FINAL DRAINAGE REPORT FOR GLENEAGLE GOLF COURSE RESIDENTIAL INFILL DEVELOPMENT FILING NO. 2

November 26, 2018
Project Number 03524

VR-18-018

A REPLAT OF TRACT G, GLENEAGLE GOLF COURSE RESIDENTIAL INFILL DEVELOPMENT, IN THE SOUTHWEST QUARTER OF THE NORTHWEST QUARTER AND THE NORTHWEST QUARTER OF THE SOUTHWEST QUARTER OF SECTION 6, T12S, R66W, 6th P.M. EL PASO COUNTY, COLORADO

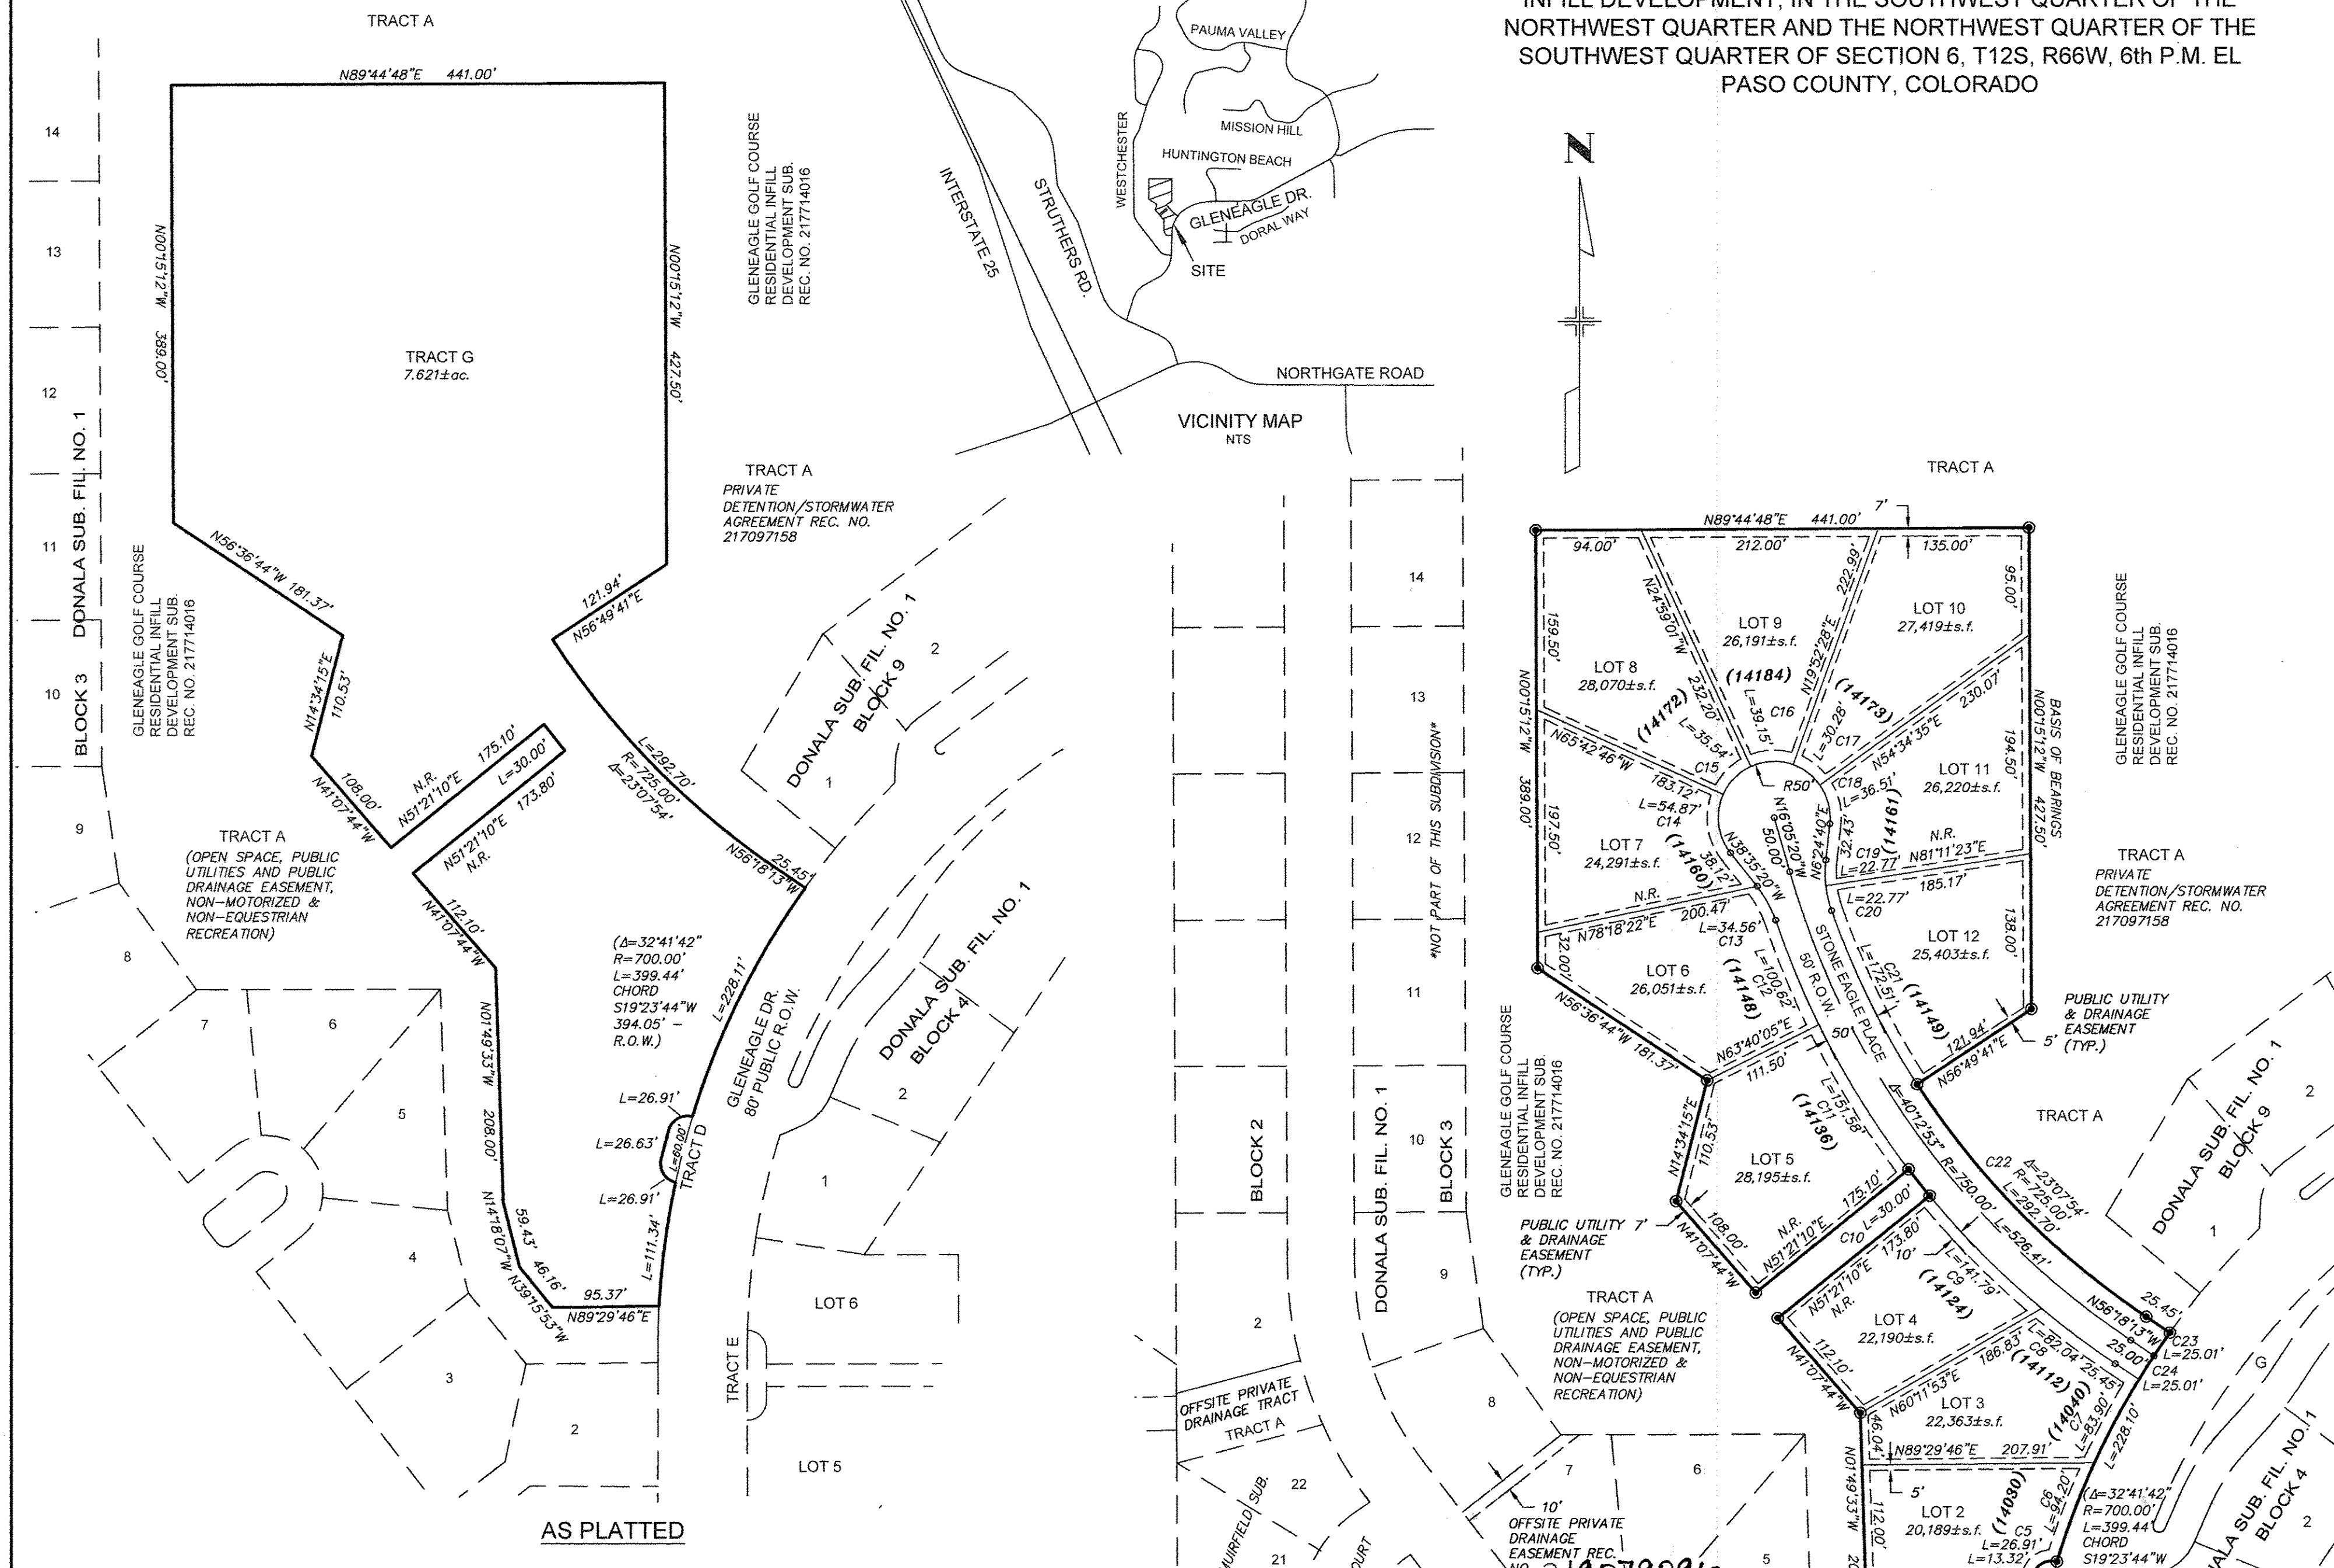
Clarify who maintains the Extended Detention Basin, All the Swales shown in the tracts the private storm sewer etc. Call out the entity responsible for ownership and maintenance. Also provide this on the Plat.
